PUBLIC WORKS DEPARTMENT

January 20, 2023

Re: **Kendall Subaru Dealership – PA22-035 – Concurrency Recommendation**

FRONTAGE IMPROVEMENT PLAN **C5.0**

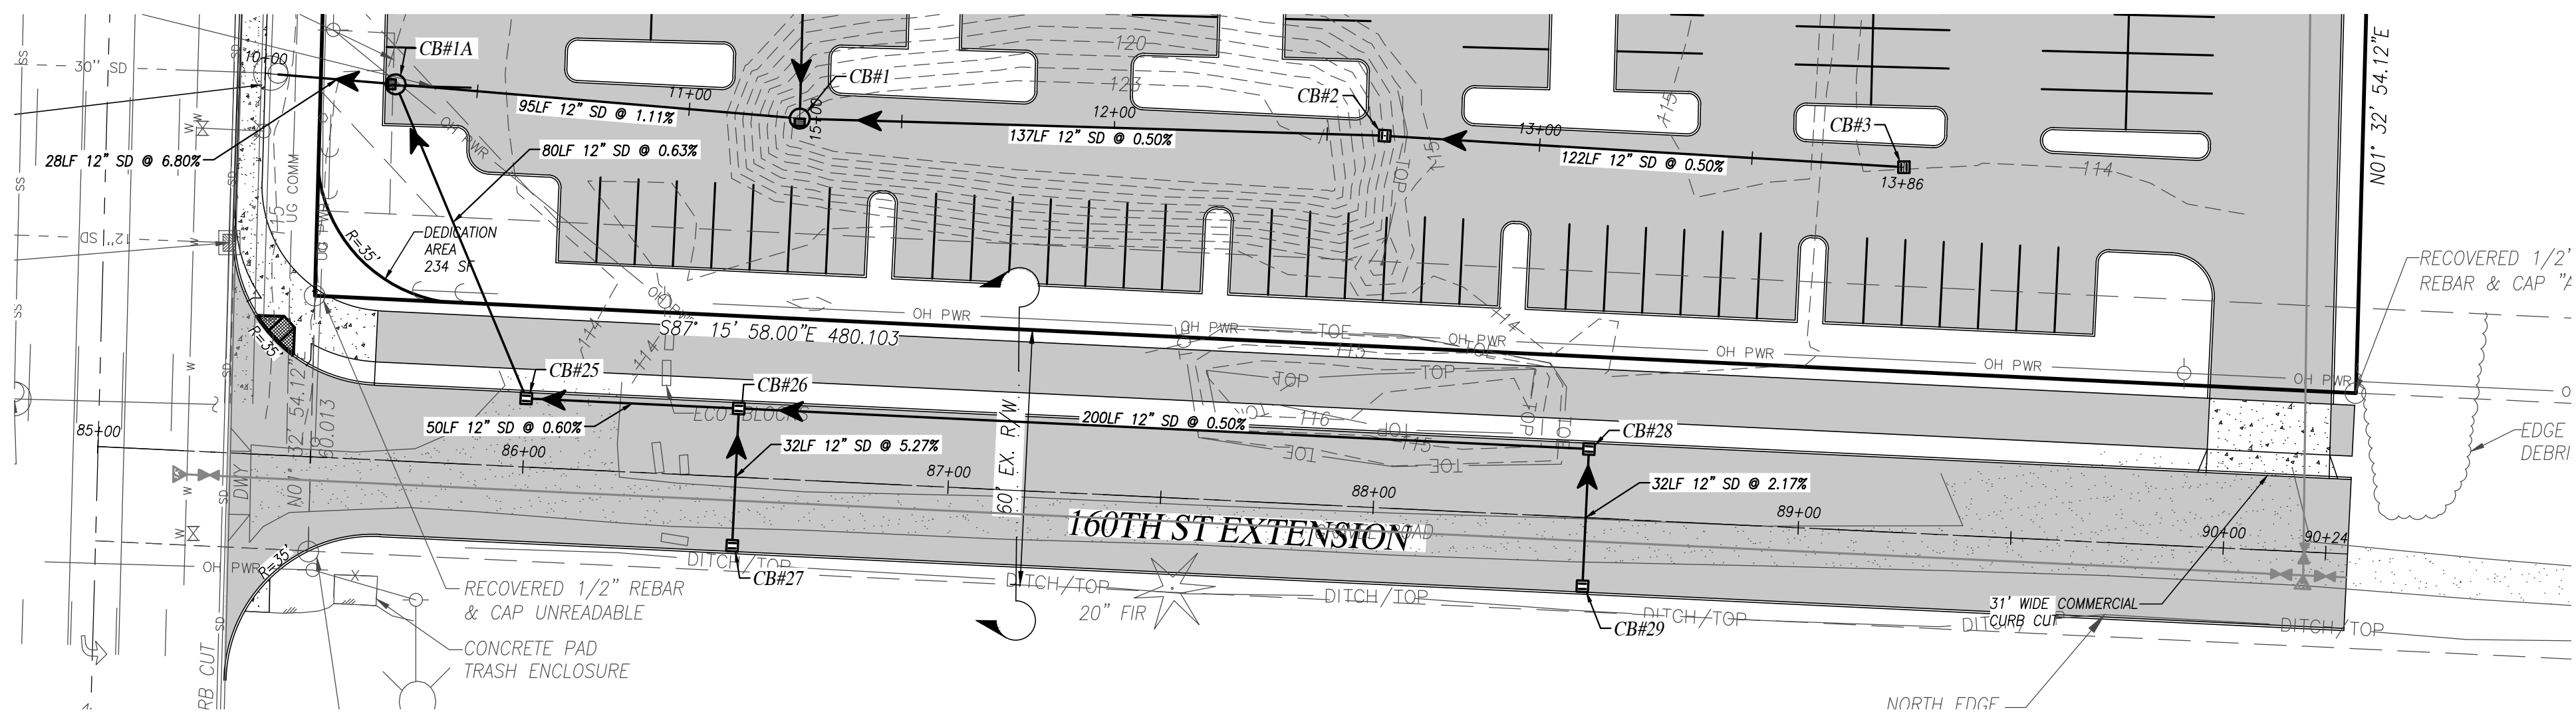
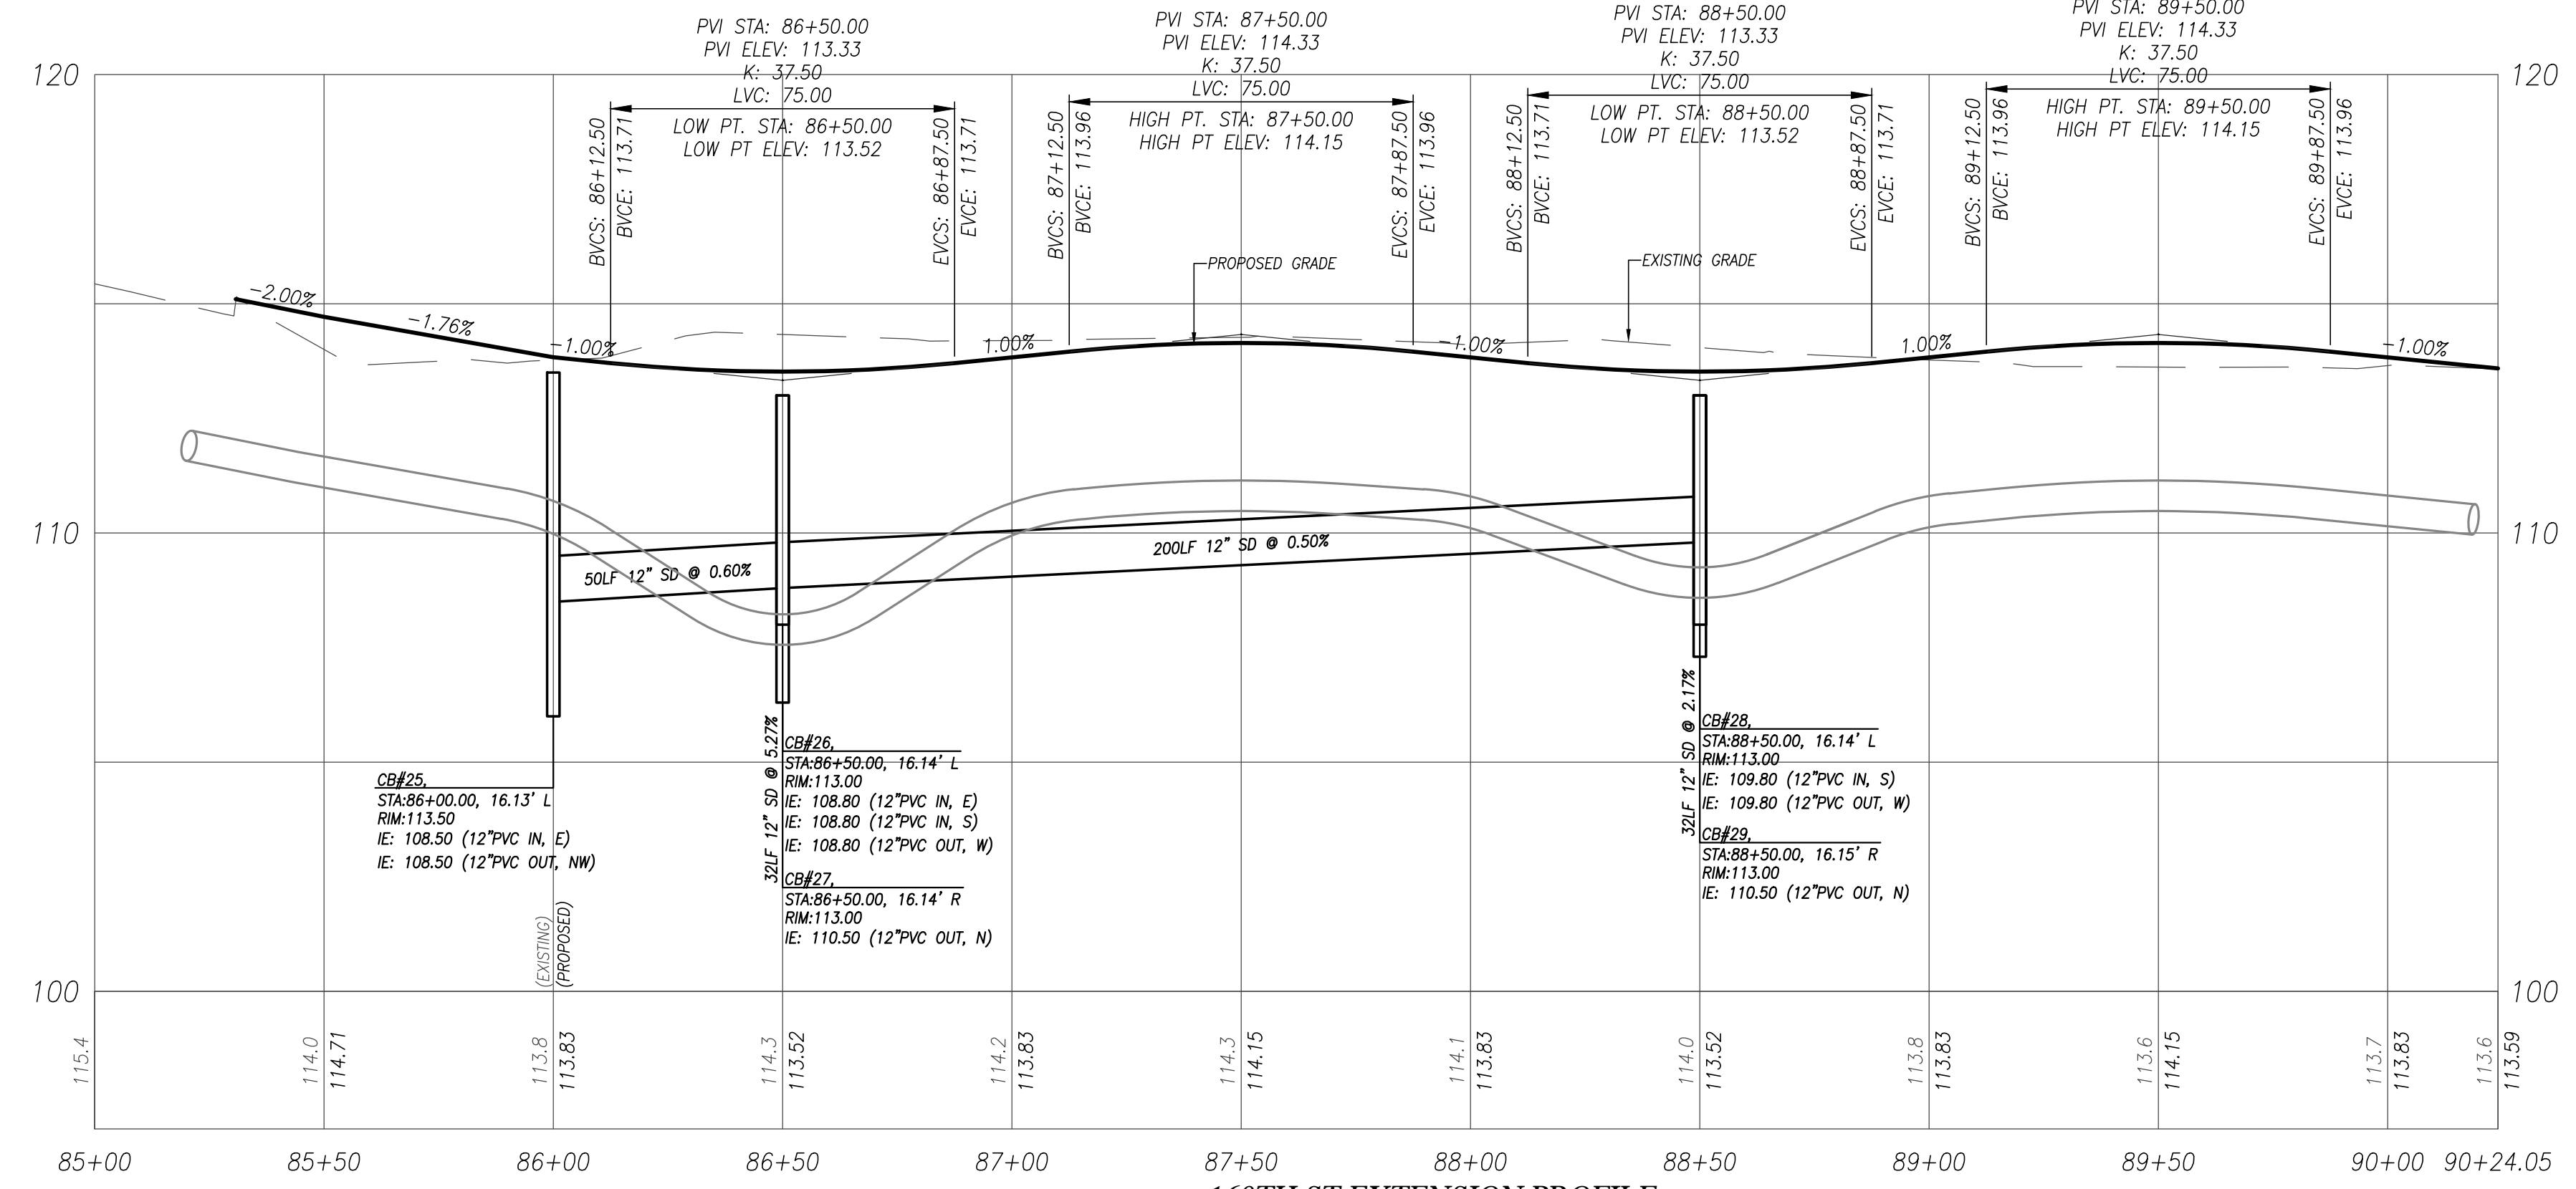
1. The applicant shall be required to construct frontage improvements along Smokey Point Boulevard and 160th St NE, including, but not limited to:
 - 2.1. The sidewalk along Smokey Point Blvd. is adjacent to the curb, as such it is to be a 6 foot wide sidewalk. The sidewalk shall be removed and replaced with a 6 foot sidewalk.
 - 2.2. 160th St NE is to be a 3 lane arterial with planter strips and a 12 foot multiuse path. The project is required to construct a half street for asphalt, which is 20 feet in width and the curb and gutter, a 5 foot planter strip and the multiuse path.
2. In order to mitigate impacts upon the future capacity of the road system, the applicant shall be required to submit payment to the City of Marysville, on a proportionate share cost of the future capacity improvements as set forth in MMC 22D.030.070(3), for the development.
